To Company:	Ironstone Developments Pty Ltd	Email:	tim@woodburycivil.com.au
Attention:	Tim Mullaney	Date:	19/5/2023
From:	Neil Pennington	Ref:	181724-RF11
Copies to:	Jonathan Berry (Wedgetail)	Pages:	4

Subject: Response to RFI – Deep Creek Quarry (SSD-11591659), Limeburners Creek NSW

This letter report provides responses to issues raised in a Request for Further Information (RFI) from the Department of Planning and Environment (DPE) dated 21 March 2023 following their review of our noise and vibration assessment for the proposal. The additional information request is reproduced below.

7

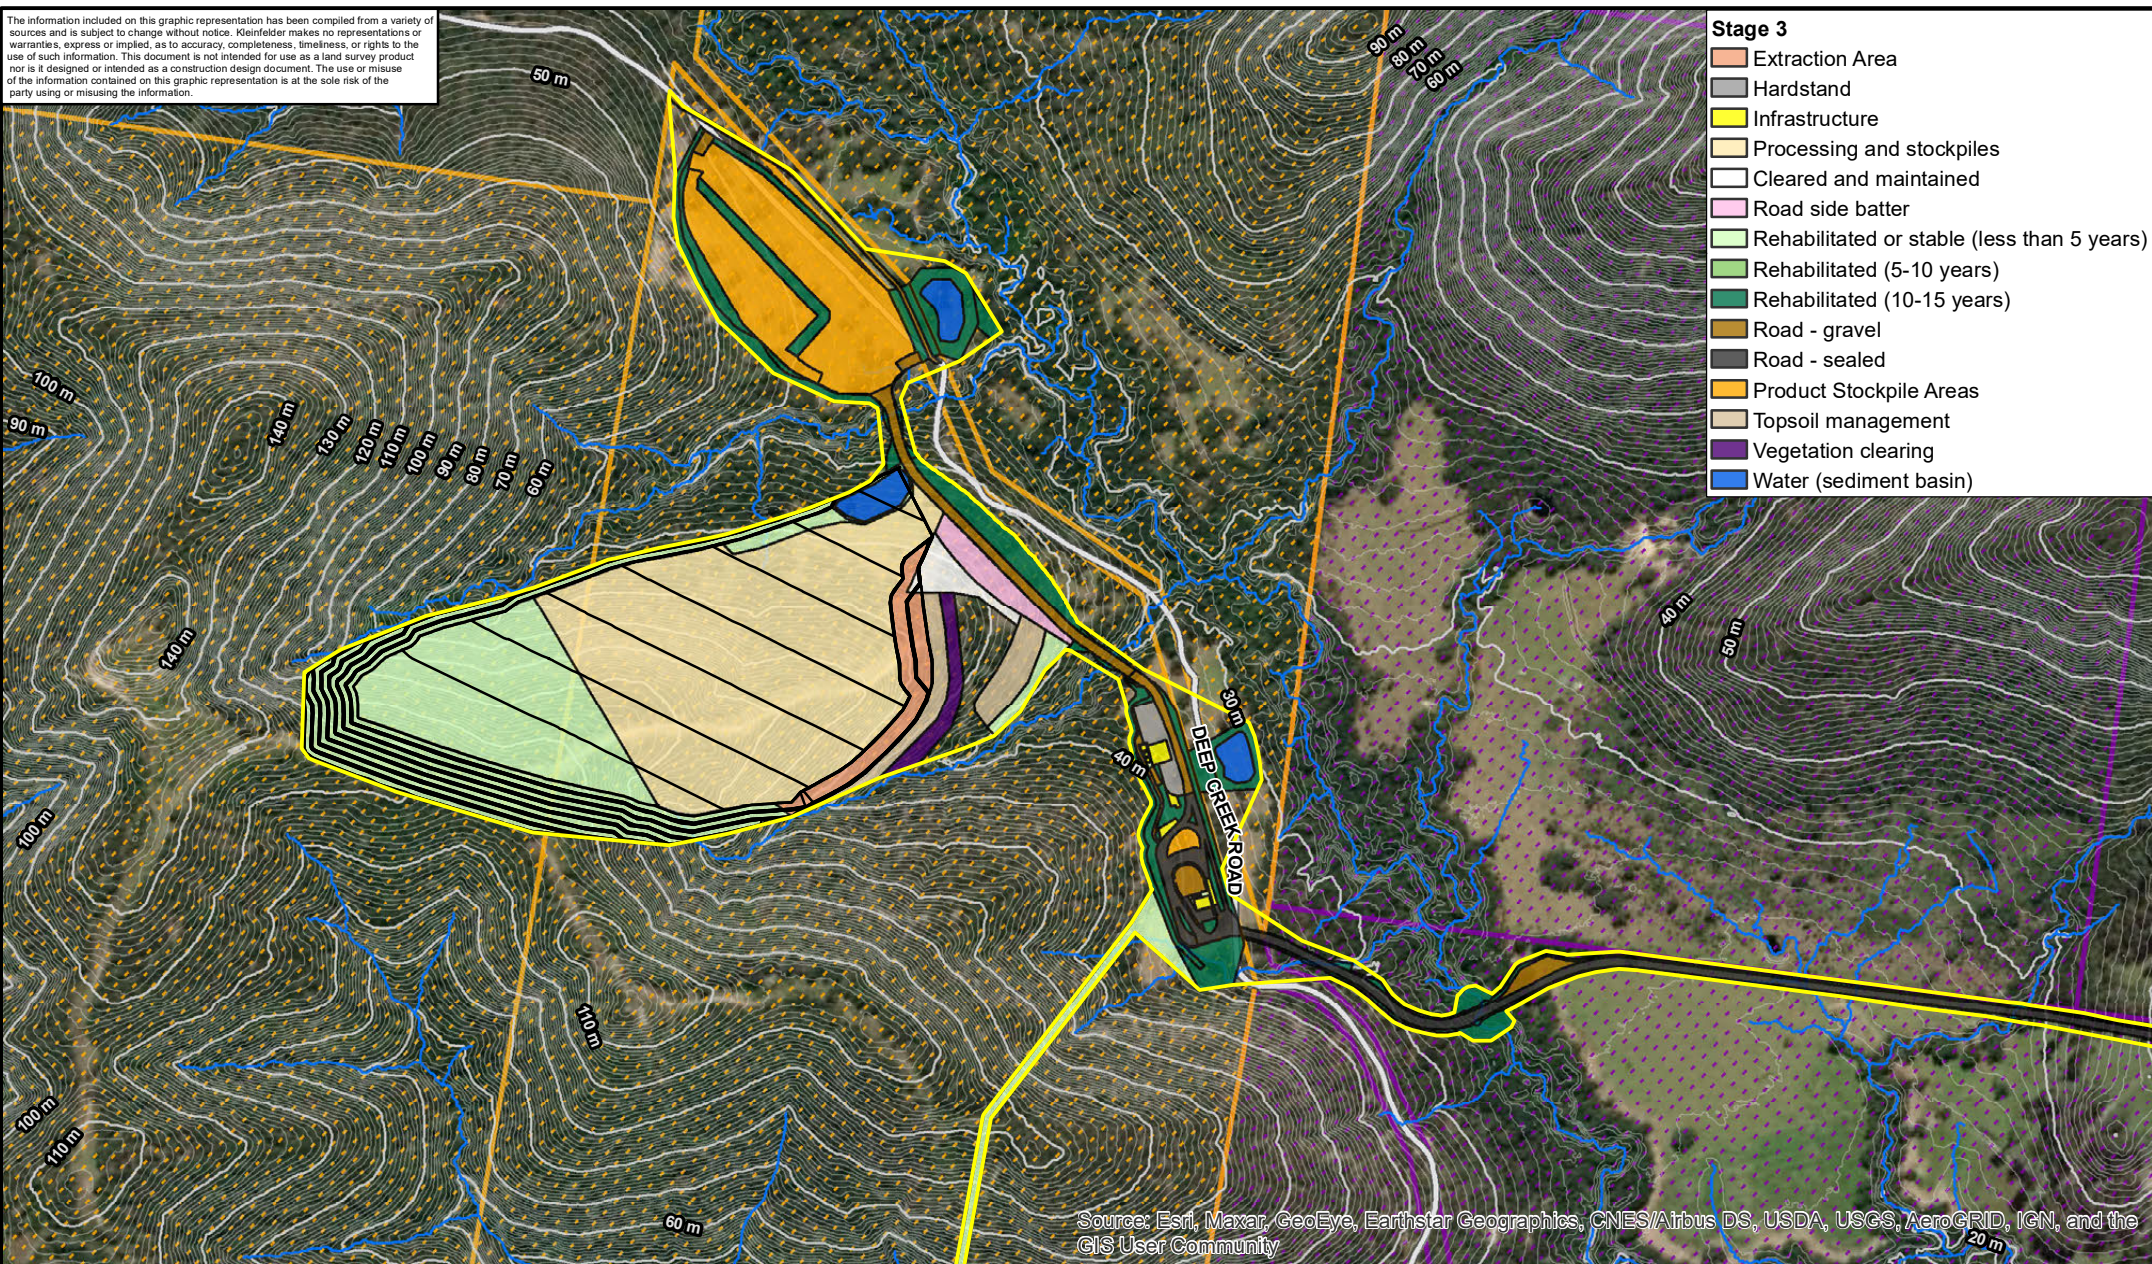
- A description of the 'noise shield' shown on Figure 6 of the NIA and an explanation as to how this has been considered in the noise model predictions.

The second point of the RFI has queried the “noise shield” indicated in Figure 6 of our original report. The Proponent has advised that this is not a constructed barrier or bund. Rather, it is ground left undisturbed to act as a natural noise barrier to emissions from latter stages of extraction. Noise source figures have since been updated (as included in this letter) and show no “noise shield”.
